Client: Persimmon Homes Thames Valley
Project Title: 19163- Sites A2 & B6 Littlehampton, West Sussex
Rev: - 1st Issue
Date – 14th May 2020

**Drainage Consultee Response for Residential Development at Hampton Park,
Parcels A2 & B6, Toddington Road, Littlehampton. Ref LU/90/20/doc**

© This drawing and the building works depicted are the copyright of Banners Gate Ltd and may not be reproduced or amended except by written permission. No liability will be accepted for amendments made by other persons.

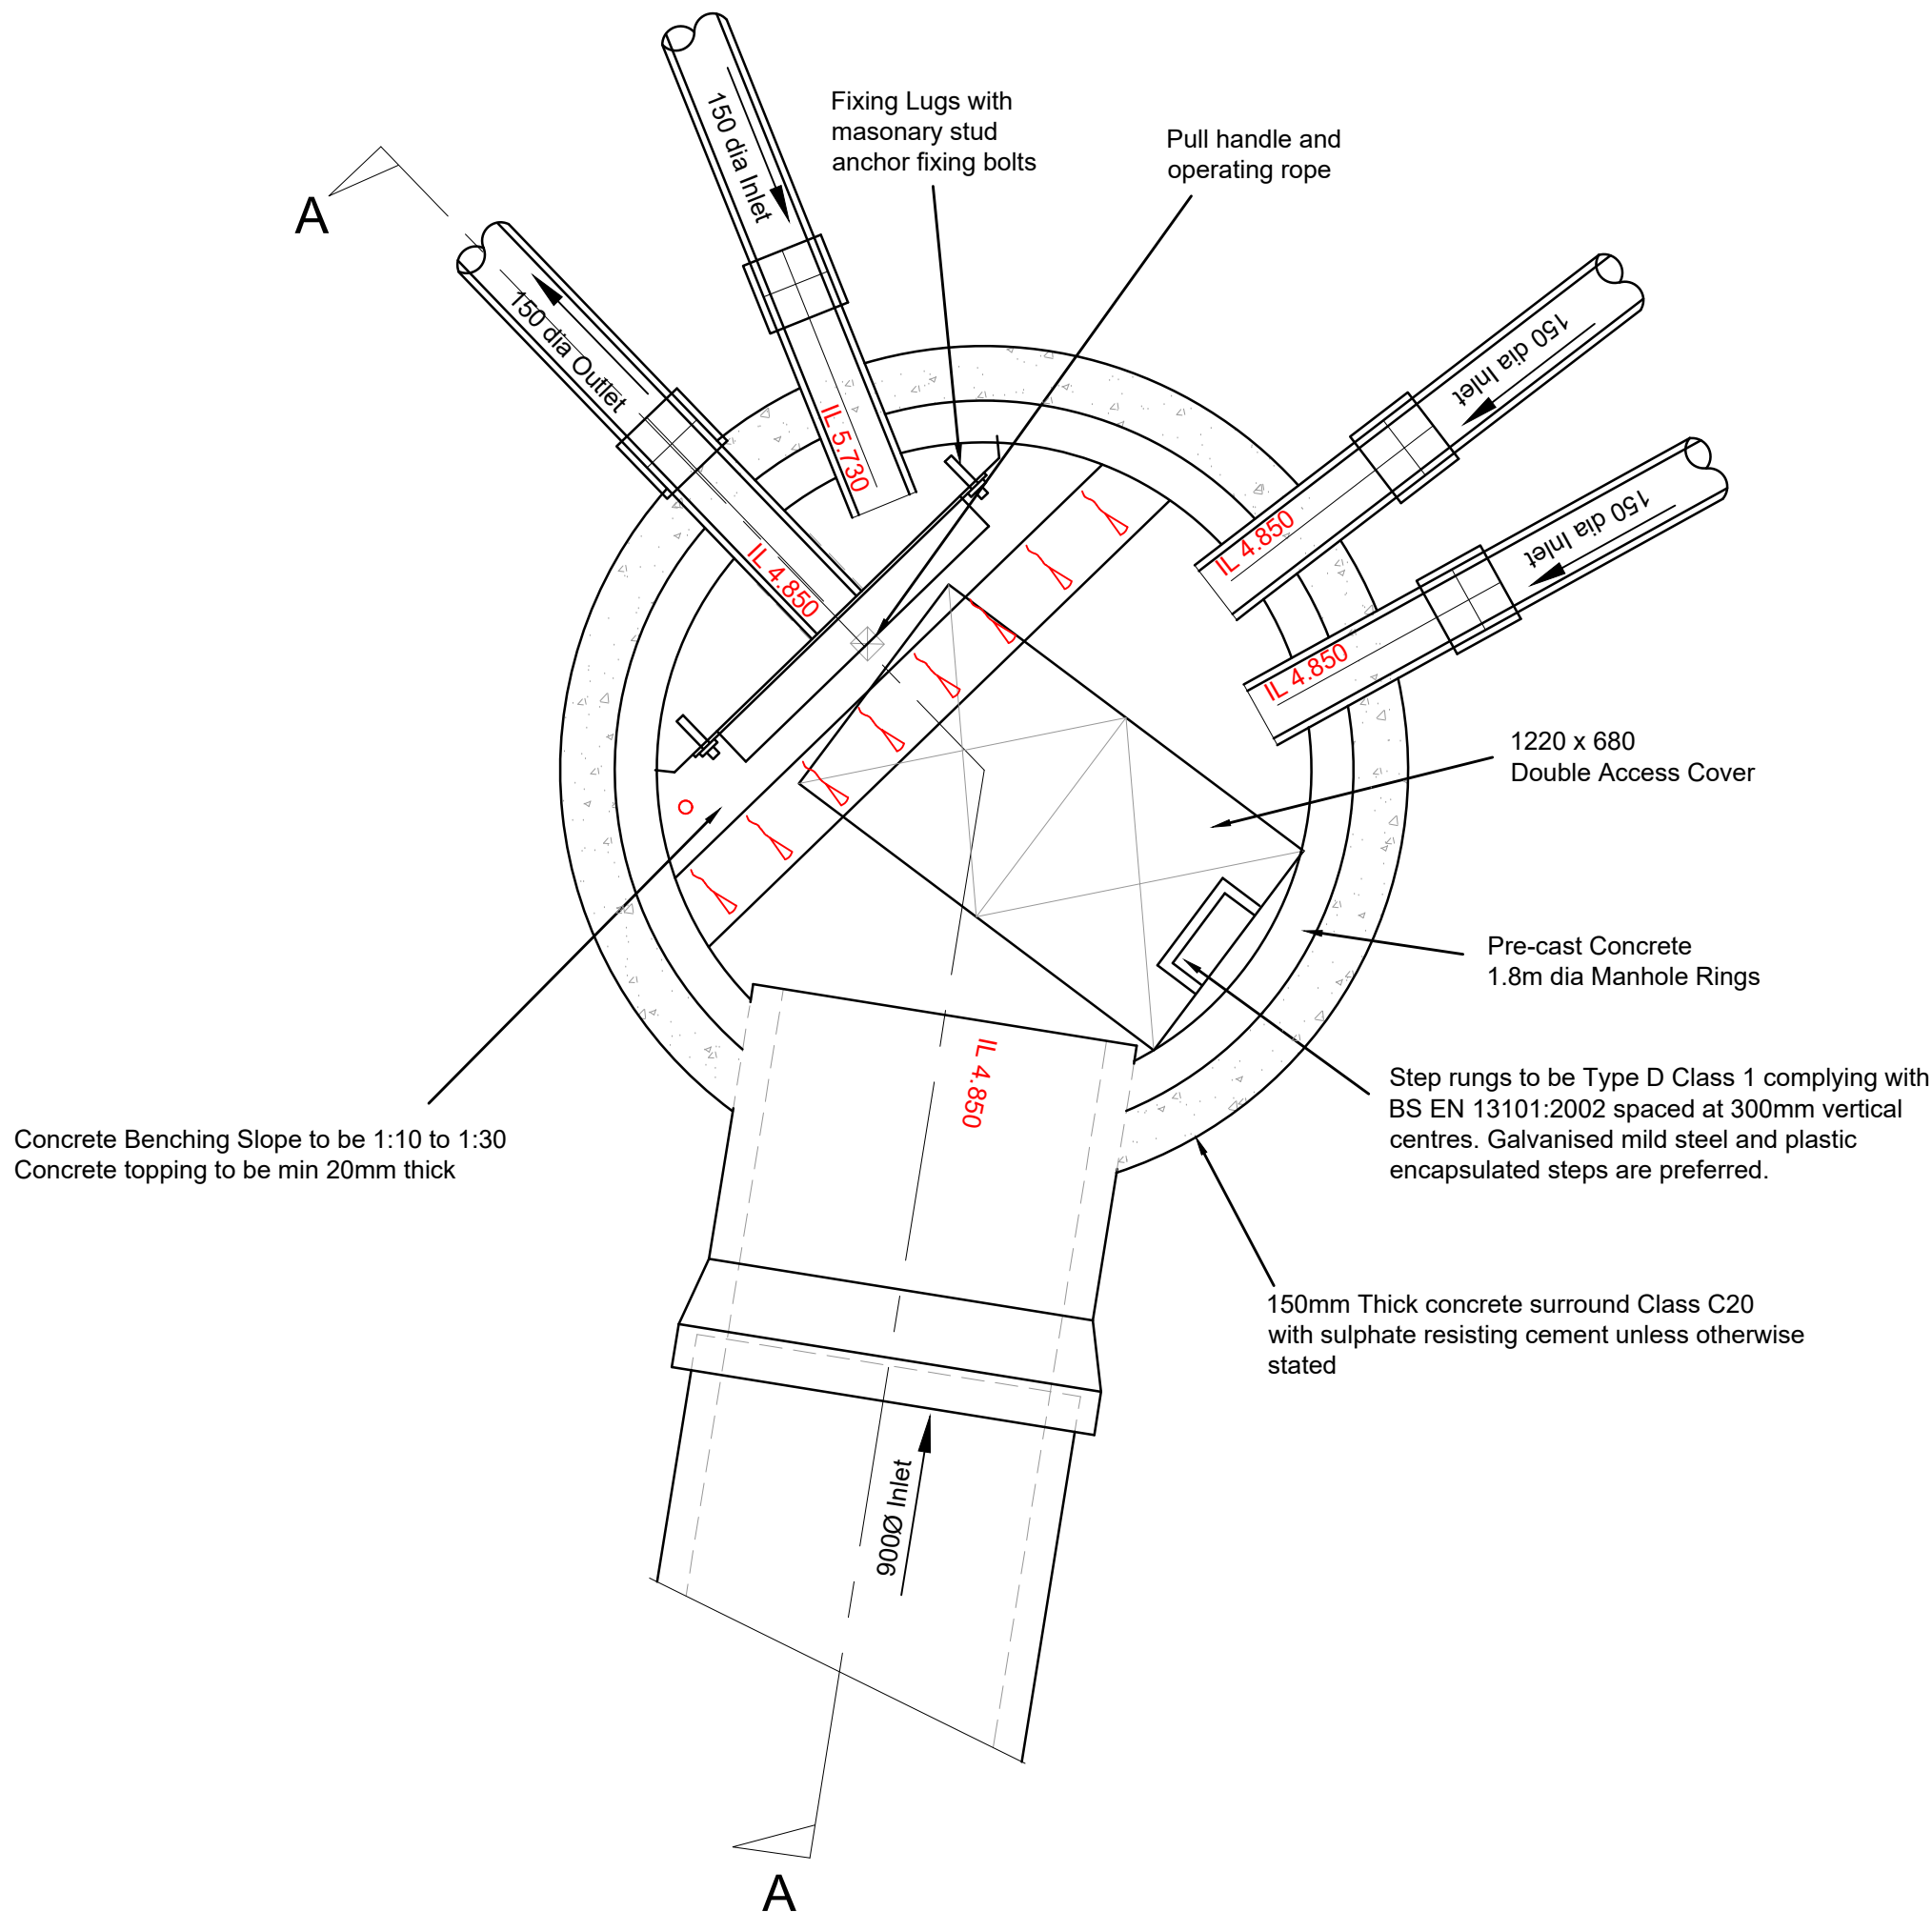
14. *Can the CS2 tank be online rather than offline? Tank now on-line as requested.*
15. *Gully north of HB2 control chamber is connecting against the flow. Reconfigure the arrangements here to improve the situation. Appreciate comment but the road gully connection is discharging to the sump of the hydrobrake. We have endeavoured to try and produce a practical design and taking into consideration the outfall location and the orientation of the various connections believe it is a more practical arrangement. It would be appreciated if the arrangement could be accepted in this instance.*
